FOSSE GREEN ENERGY EXAMINATION

COMMENTS ON DOCUMENT REP1-047 – THE APPLICANT'S RESPONSE TO RELEVANT REPRESENTATIONS

ANDREW KEELING (IP Ref: [REDACTED])

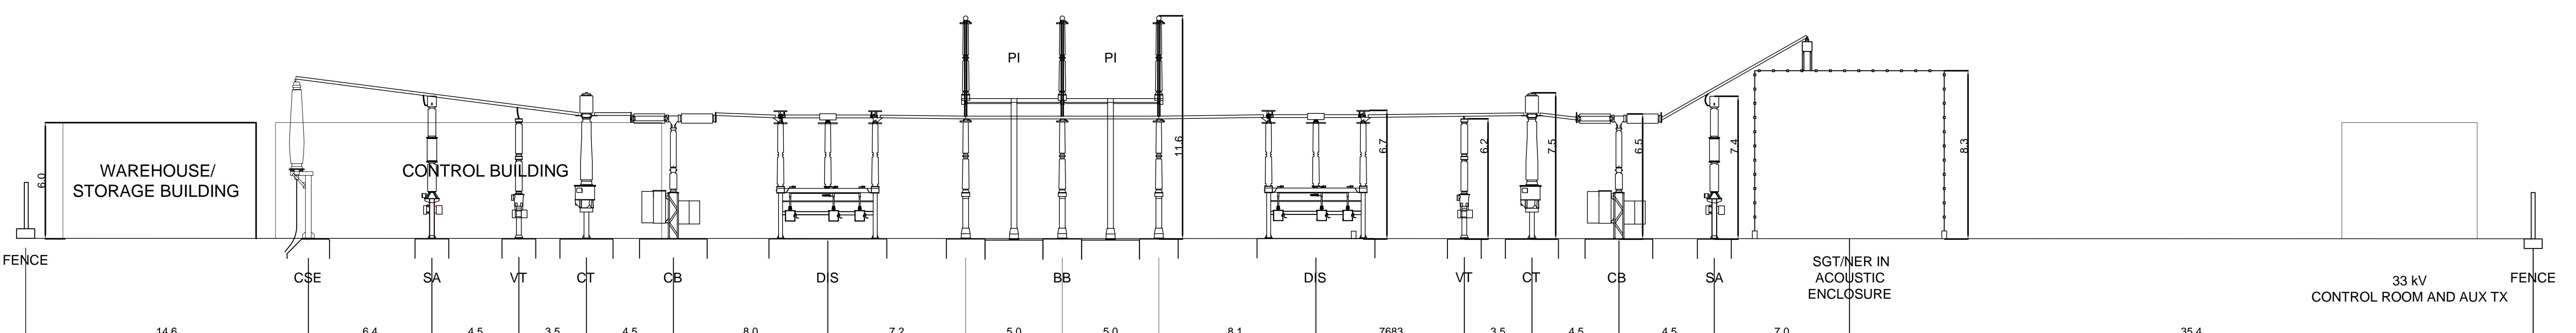
- The stretch of the Aubourn and Bassingham Long Walk to the south of Aubourn Moor, where the footpath will have solar panel arrays on either side;
- The footpath at Aubourn Moor, which will be significantly impacted by the substation;
- The stretch of the Aubourn and Bassingham Long Walk that runs further south from Aubourn Moor to Fen Lane, which will have visible solar panel arrays to the east of much of its length;
- The footpath to the west of Bassingham/ east of Clay Lane, which will have solar panel arrays immediately to its west.

Figure 3-3

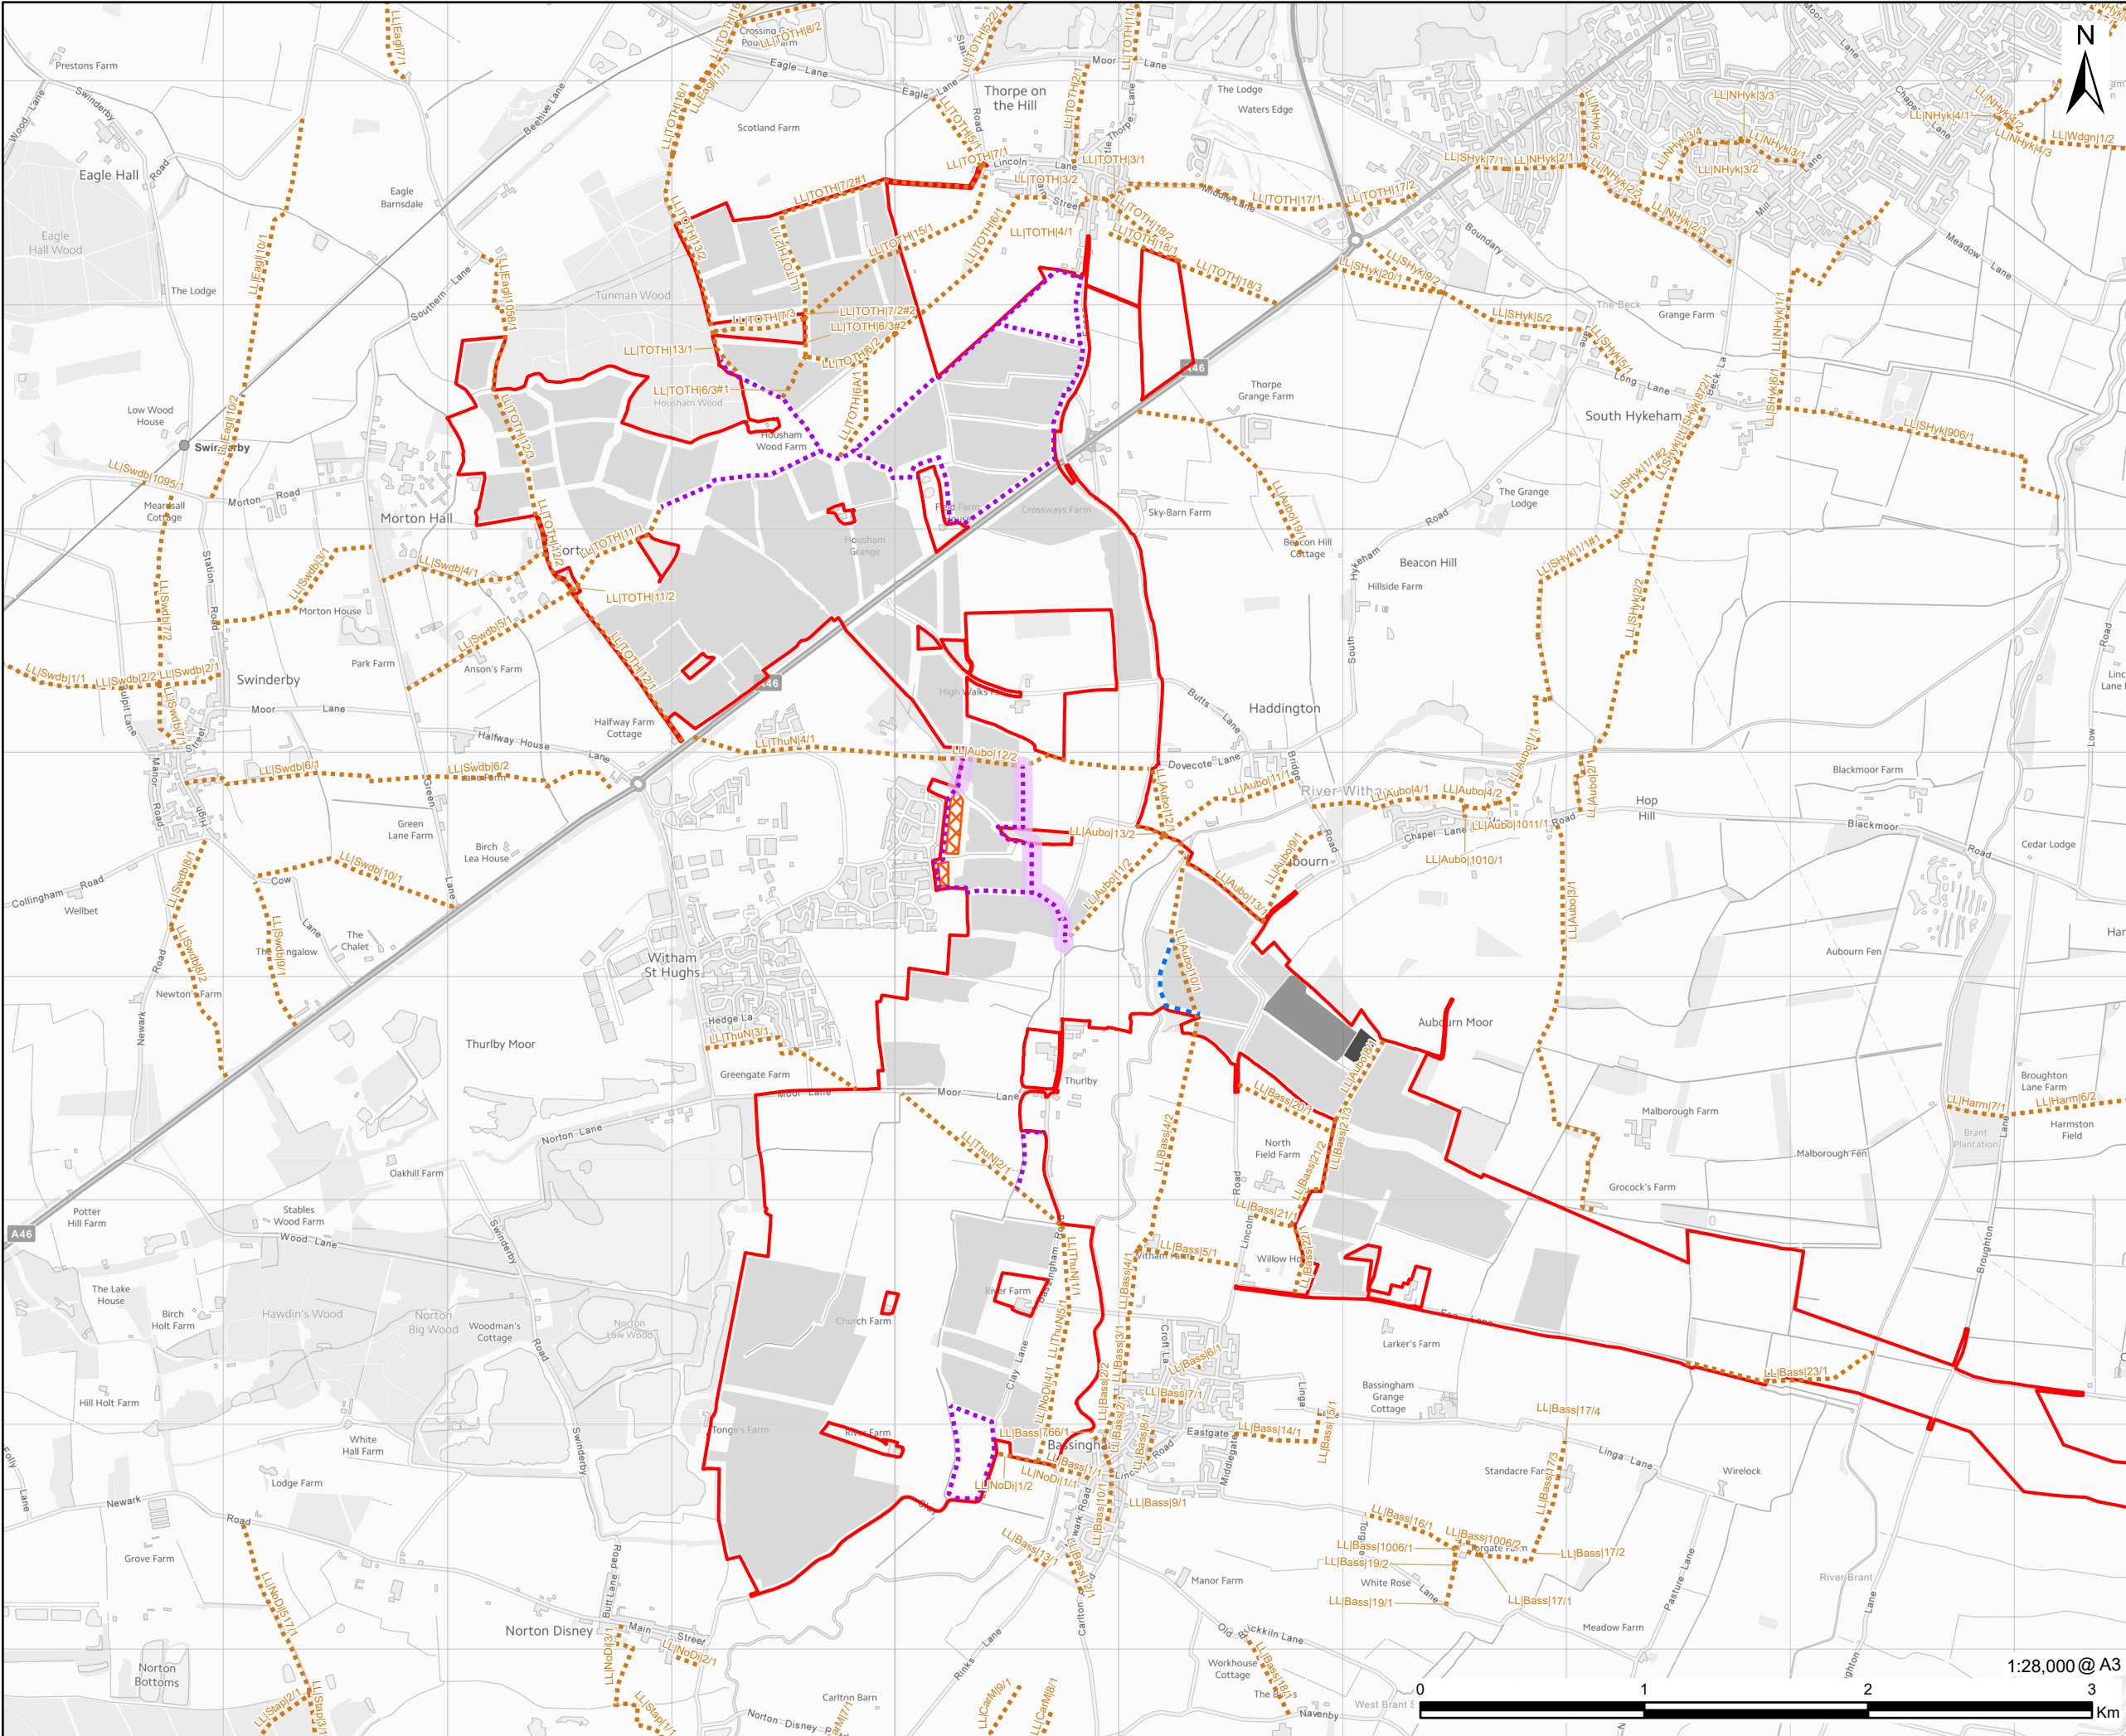
The applicant also claims that the design of the scheme includes enhancement measures in terms of the provision of a number of permissive paths to supplement the existing PRoW network. The applicant provides no evidence however of the rationale for these permissive paths, and no evidence of attempts to assess whether local people will welcome and use them. They cannot really claim them as enhancements unless this is the case, particularly when set against the negative impacts of the Fosse Green Energy project on the existing country walks that local people currently enjoy. As an example, the proposed permissive circular path off Clay Lane to the west of Bassingham is an a piece of flat, featureless land, and will have solar panel arrays on its northern edge, and distant views of solar panels to the west. I contend that it will have limited recreational appeal, and doubt that it will be used much by Bassingham residents, who currently enjoy a circular walk around the village using the footpath to the east of Clay Lane and the recreational opportunities and countryside views offered by the Holmes Parish Woodland. Furthermore, the applicant gives no consideration to more attractive enhancement opportunities, such as the creation of riverside walks, green corridors and nature reserves.
